**KIRKLEES METROPOLITAN COUNCIL
INVESTMENT & REGENERATION SERVICE**

**DELEGATED DECISION TO DETERMINE APPLICATIONS FOR
CONSENT, AGREEMENT OR APPROVAL REQUIRED BY CONDITION**

Reference No:	2024/44/90482/E
Site Address:	Land at, Whitley Road, Whitley, Dewsbury, WF12 0LZ
Description:	Discharge conditions 4 (boundary, 5 (drainage) on previous permission 2023/92700 for reserved matters application for erection of one dwelling pursuant to outline permission 2020/93432 (APP/Z4718/W/21/3274396) for erection of residential development
Recommending Officer:	Nicole Helliwell

DECISION – DISCHARGE OF CONDITION APPROVED

2M HIGH HIT AND MISS
TIMBER FENCE

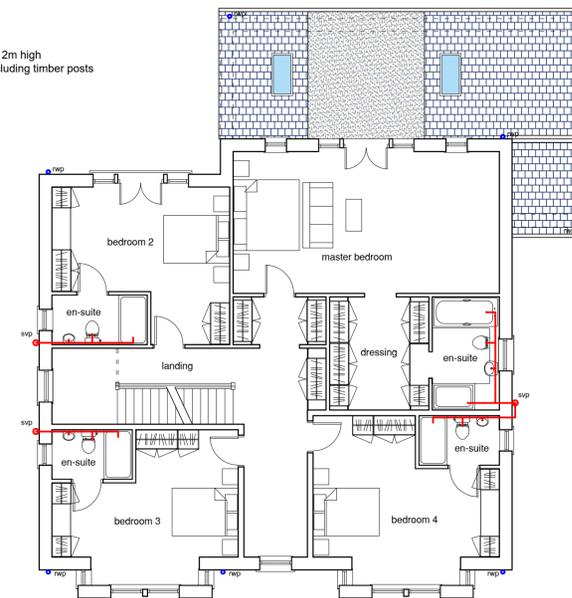
The applicant has submitted a document titled 'Proposed Drawing Conditions' (dated 06/02/2024, ref. 06) which details the location, height and materials of the proposed boundary treatments. The proposed boundary treatments would comprise a low level wall to the north of the application site with artificial stone copings and iron railings. The stone wall would have an overall height of 0.9m and would not cause any significant harm to visual amenity given that low level walls are a common feature within the streetscene. Furthermore, a hit and miss fence would be erected along the eastern and western boundary of the site. The fence would measure 2m in height and would be constructed in timber. These details are deemed acceptable for the purposes of the condition and therefore Condition 4 can be discharged. This is subject to the hereby approved boundary treatment being completed in accordance with the approved details and thereafter retained.

In conclusion, the submitted details are considered acceptable for the purposes of the Condition 4 and therefore the condition can be discharged. This is subject to the hereby approved boundary treatment being completed in accordance with the approved details and thereafter retained.

SITE / GROUND FLOOR PLAN

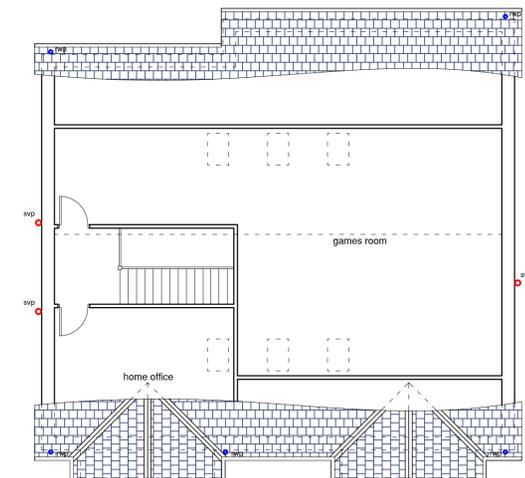
The applicant has submitted a document titled 'Proposed Drawing Conditions' (dated 06/02/2024, ref. 06) in support of condition 5.

The site is not within a flood risk zone or a critical drainage area. It is considered that as the proposal is for one dwelling, the evidence submitted is sufficient to demonstrate that proposed drainage methods are suitable for this site.

can be approved. Subject to the drainage arrangements being implemented before the dwelling is first occupied and thereafter retained, the condition will be complied with.
